MEMORANDUM

SUBJECT: SF-19-013 – Creekside at Lorson Ranch
Second Submittal – response to comments

Channel Construction Plans and Design Report (also in CDR-19-002)

LORSON RANCH
 CREEKSIDE DEVELOPMENT
 EAST FORK JIMMY CAMP CREEK
 CHANNEL PLAN AND PROFILE STA 22+00 TO STA 35+00
 EL PASO COUNTY, COLORADO

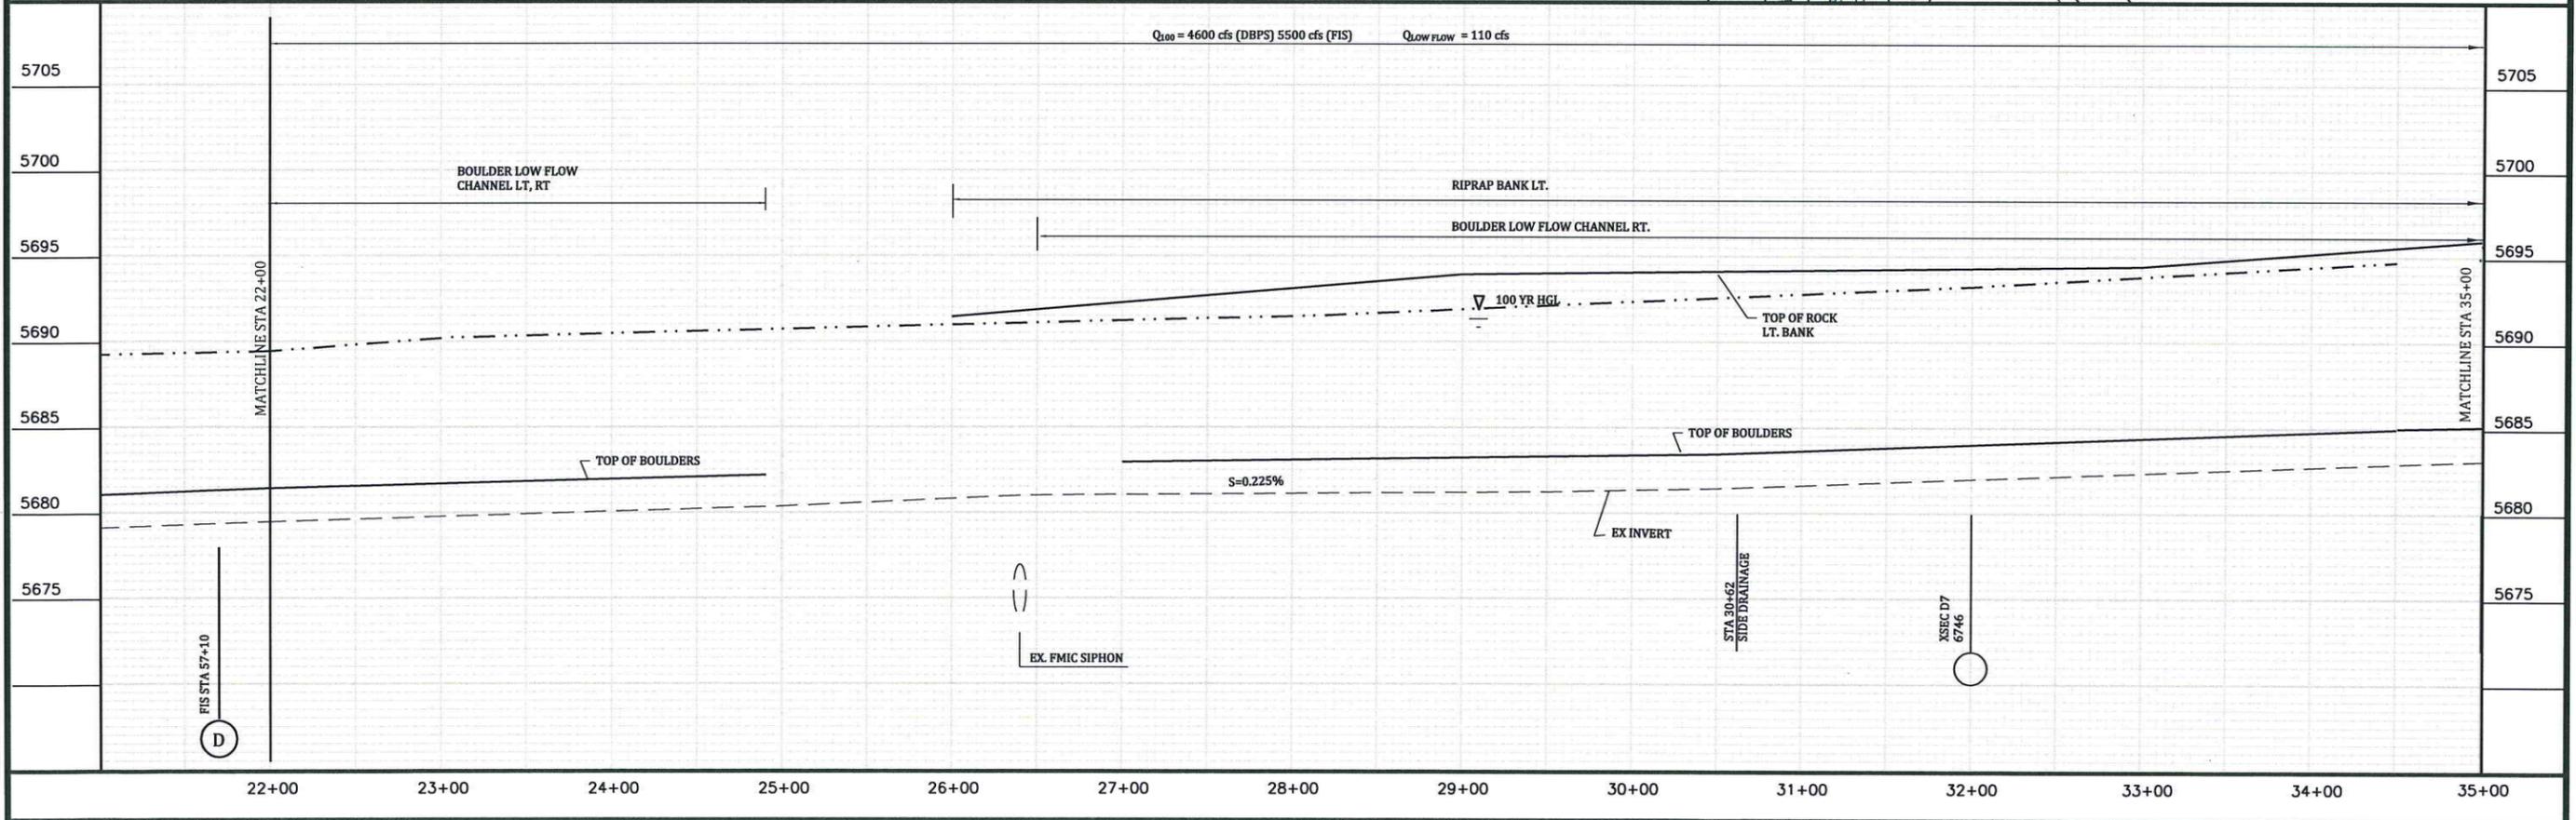
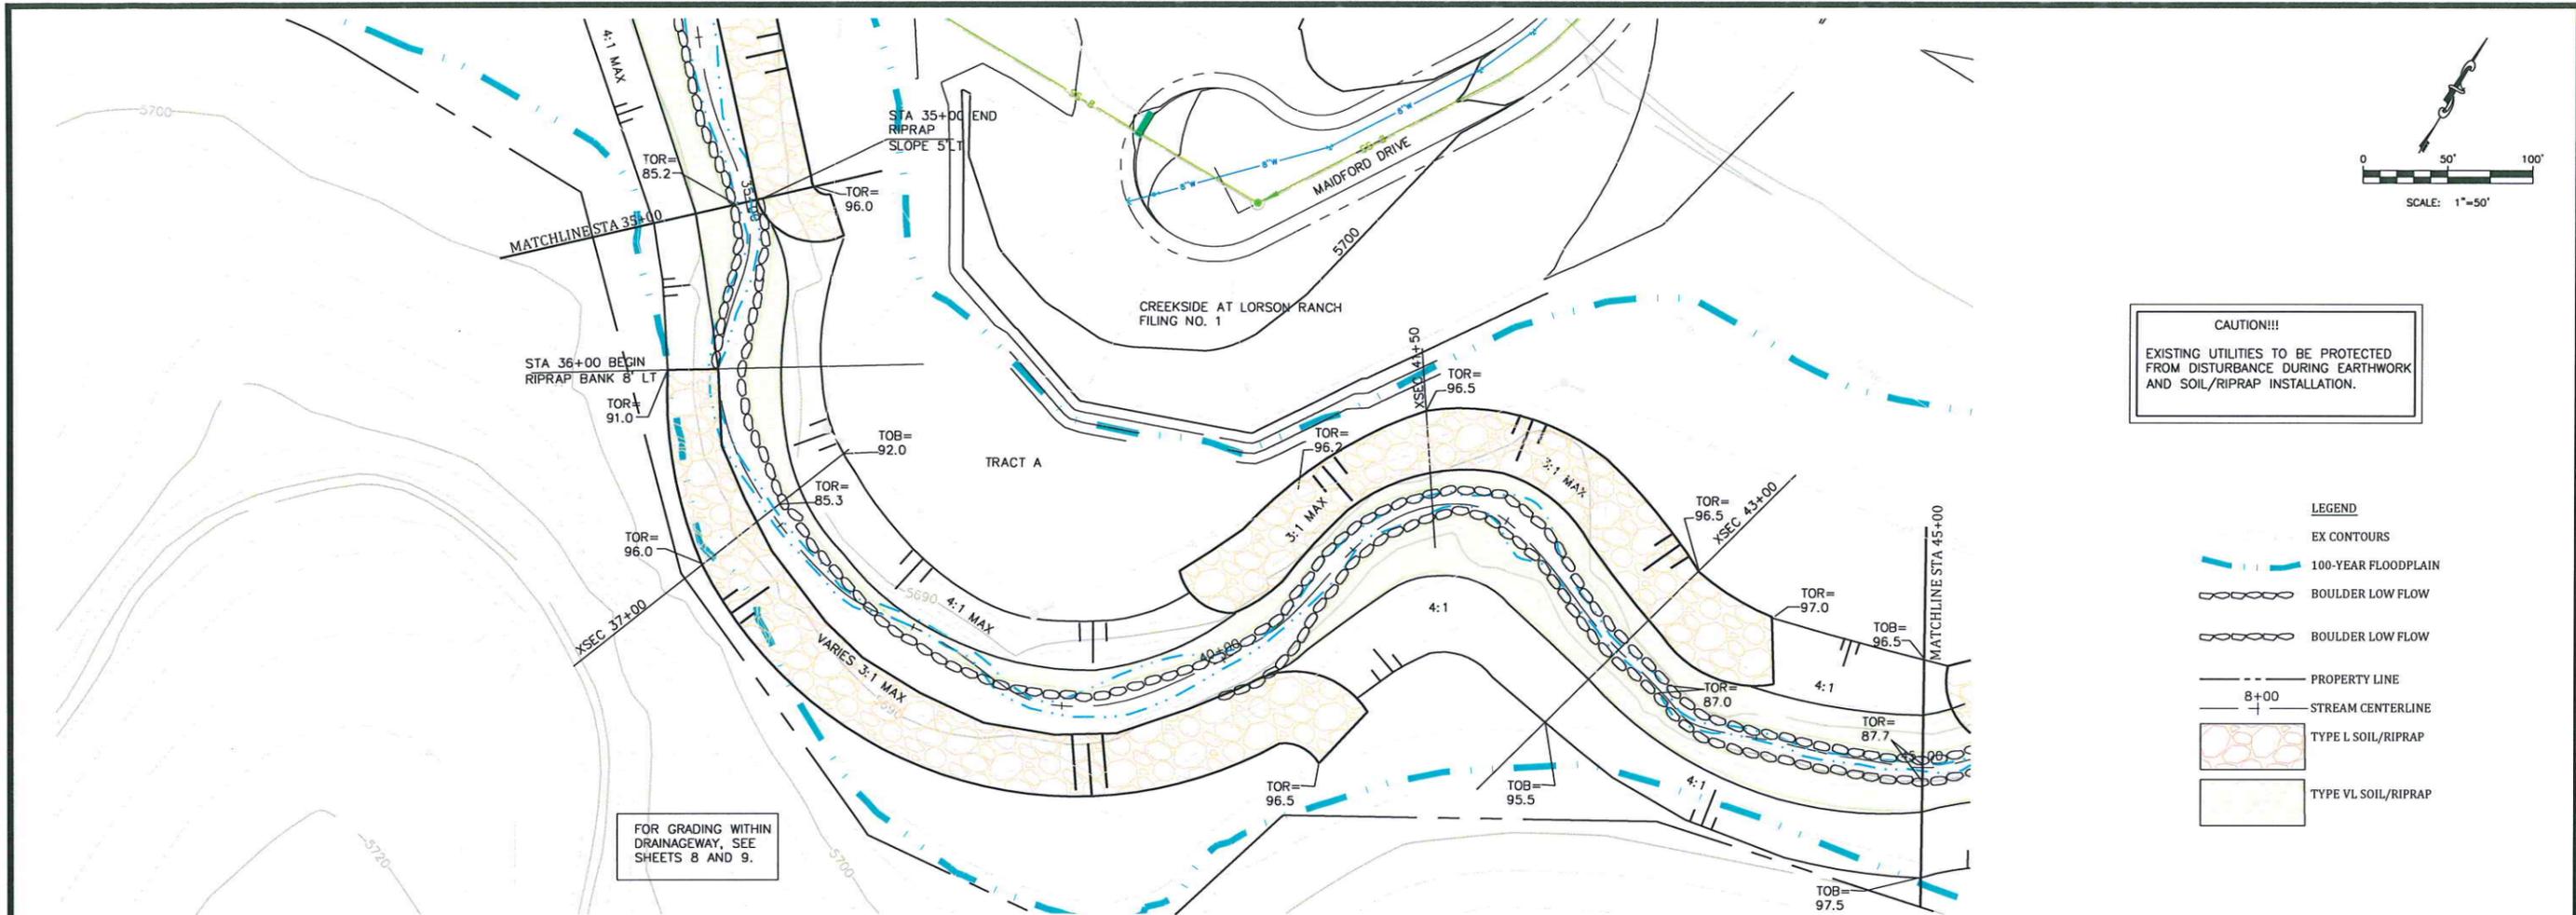
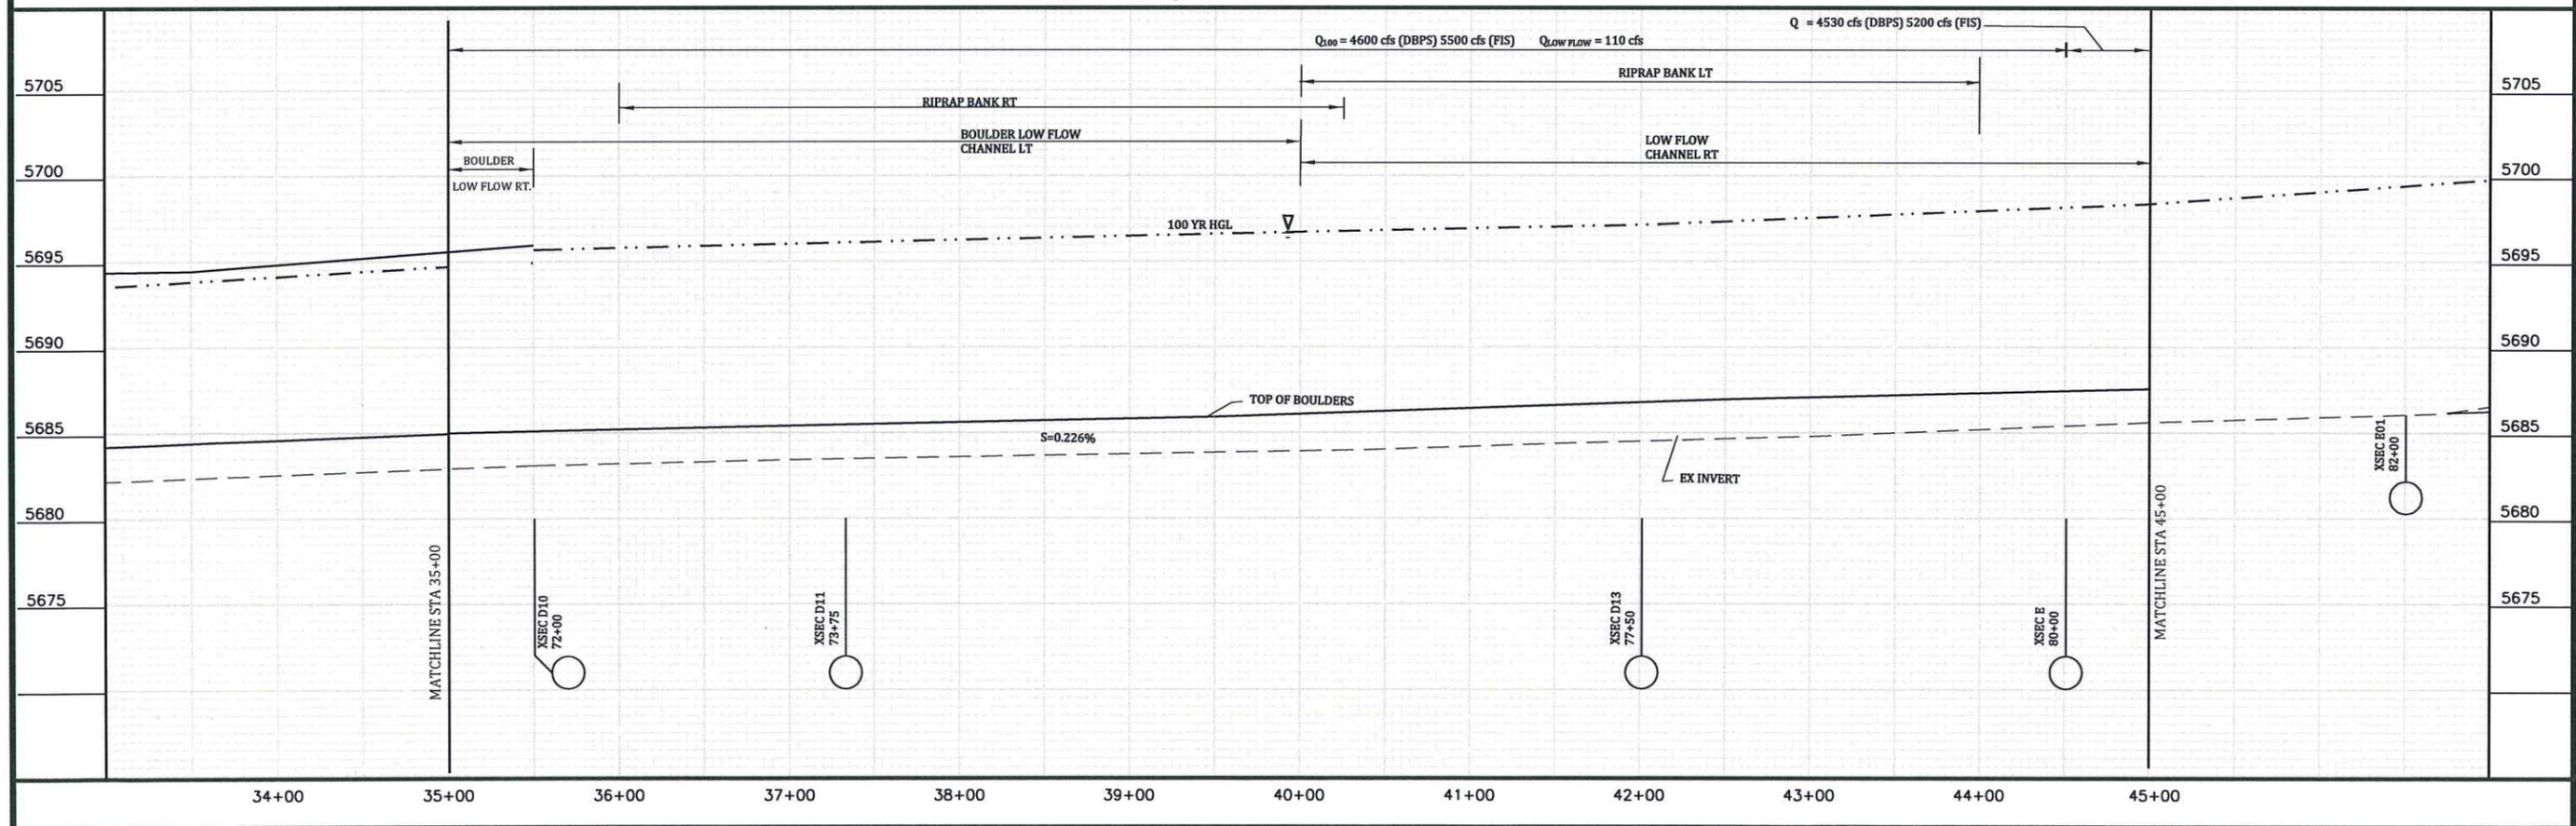
5. **It appears that at least one additional grade control (drop or check) structure is required between the two proposed structures to minimize potential channel degradation. Consider placing a drop or check structure at the location of a drop structure shown in the DBPS corresponding to Station 30+00 on the plans. Reference UDFCD Chapter 9, Section 2.9. Please discuss with Staff.**
